From: Lisa Jackson [REDACTED]
Sent: 28 September 2022 17:29
To: Simon Davis
Cc: Jonathan Stone; Andy Higgins; Bava Sathan (BavaSathan@campbellreith.com)
Subject: Re: Y/55/22/DOC Crematorium

Condition 8:

Drainage Construction Details Proposed Basin Detail Sheet 1 of 2

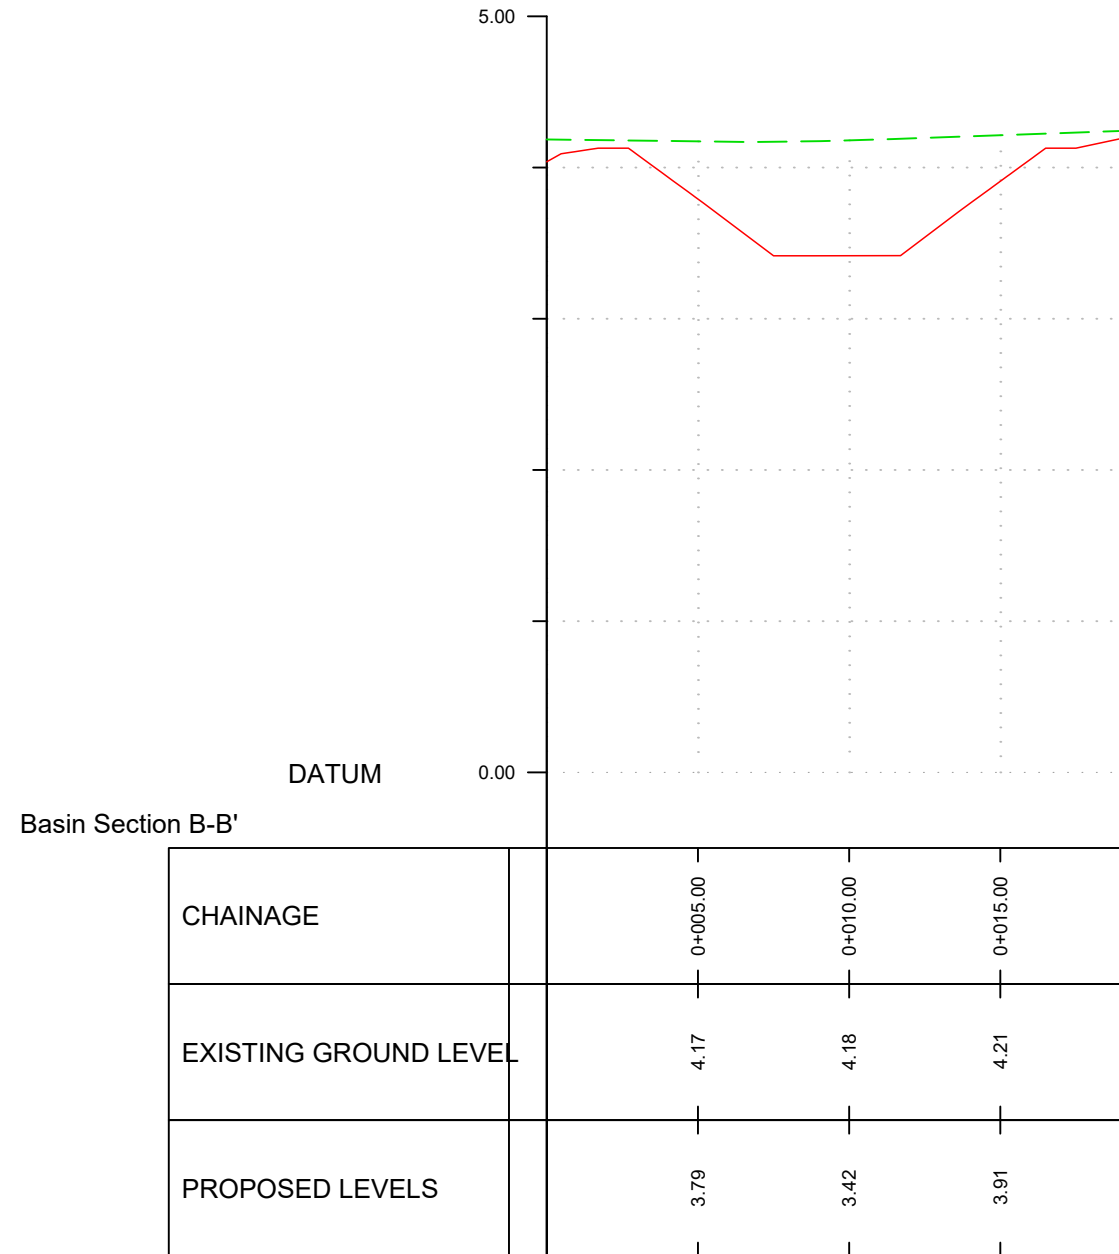
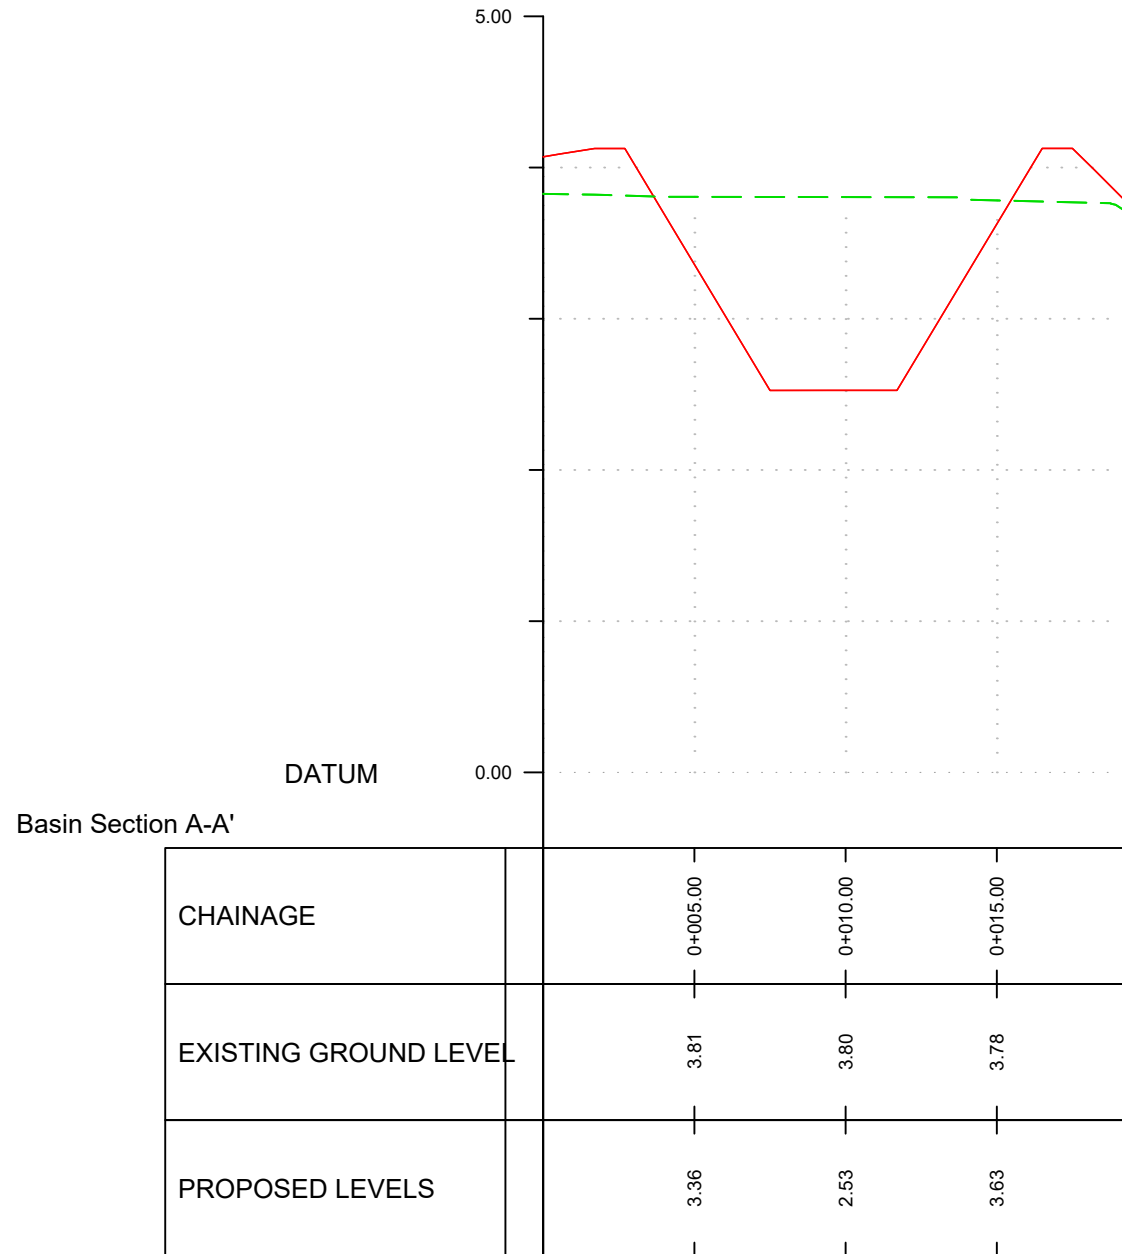
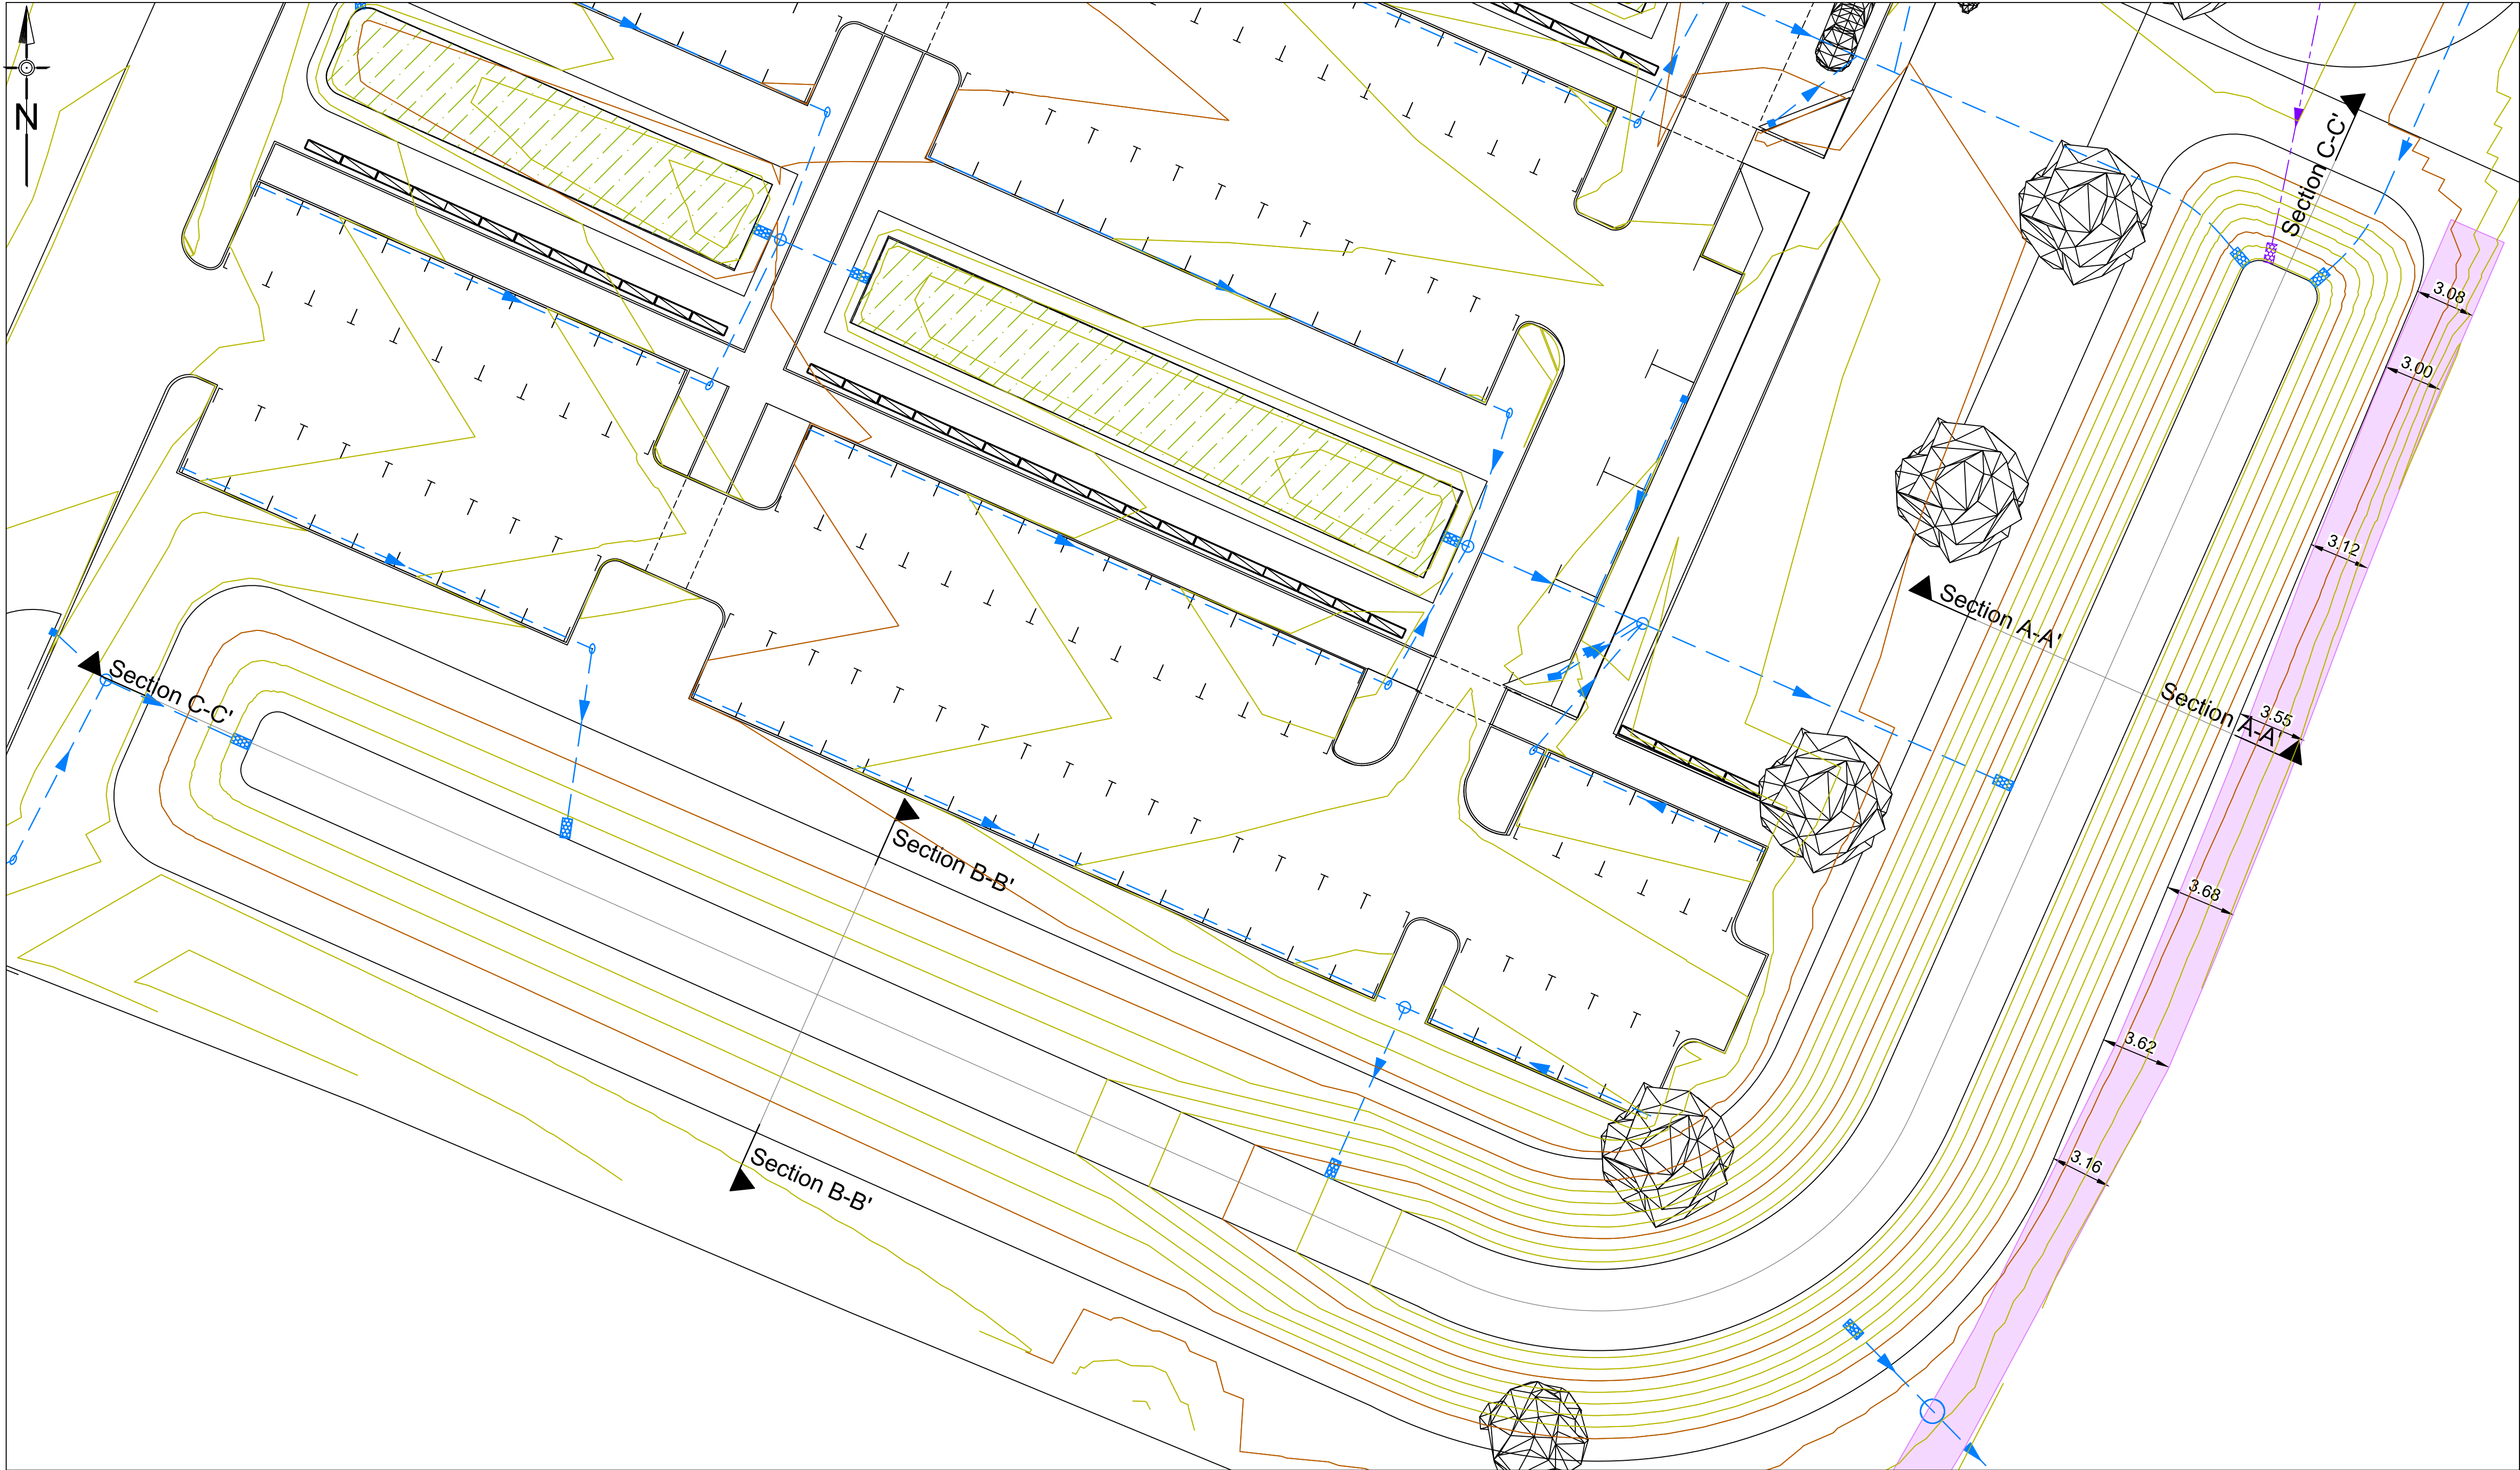
vi. An orifice of 0.0001 has been used in microdrainage calculations as a dummy node to simulate the outfall from the basin into the watercourse. The invert of the outfall (3.00mAOD) is at a higher level compared with the basin invert (2.60mAOD), however, Microdrainage will not allow a hydrobrake to be positioned 'above' the invert level of the flow control node. Therefore it was necessary to introduce a dummy flow control at the base of the flow control chamber with no outflow. This will not be present in the physical scheme and does not appear on the construction issue drawings.

vii. Construction issue plans have been enclosed for completeness (ref 1).
